From: Karen Lewer [REDACTED]
Sent: 24 April 2017 20:18
To: Simon Davis
Subject: Attached objection

Condition 6: landscaping:

Condition 10: lighting:

Tree and Hedge Planting

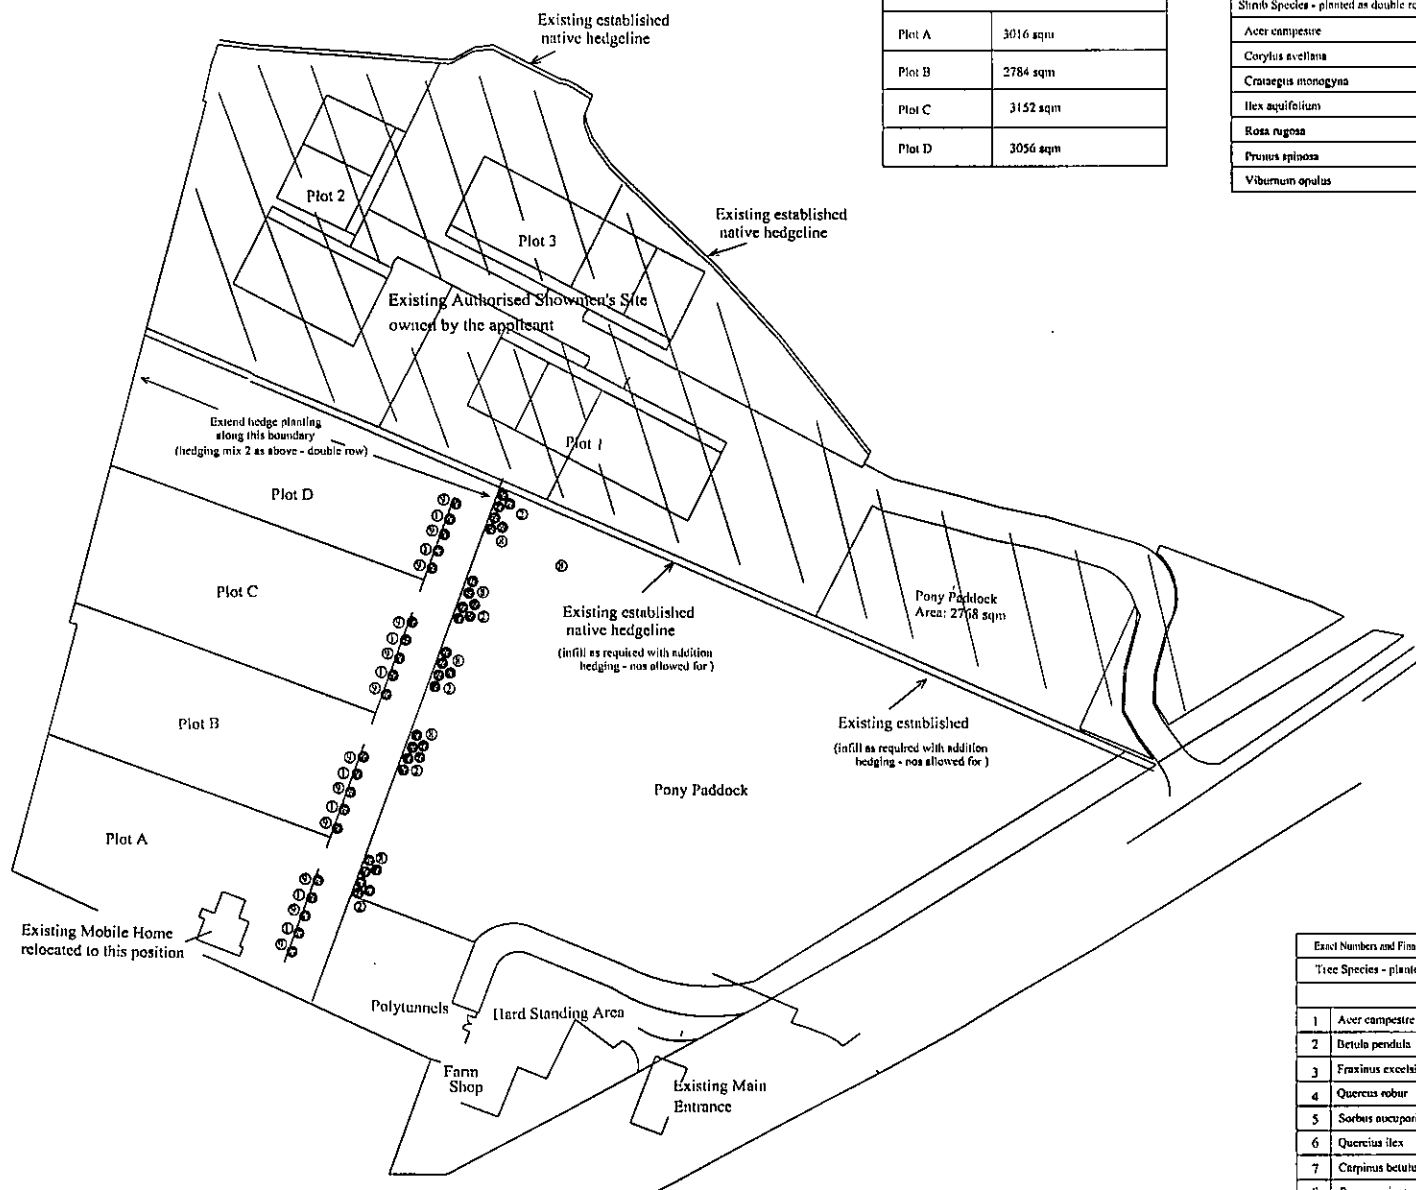
The plan available to view shows very little landscaping and does not include the additional landscaping we have requested along the border to the site that we view from our home. We have requested mature plants to ensure we no longer have to view this site from our home and garden.
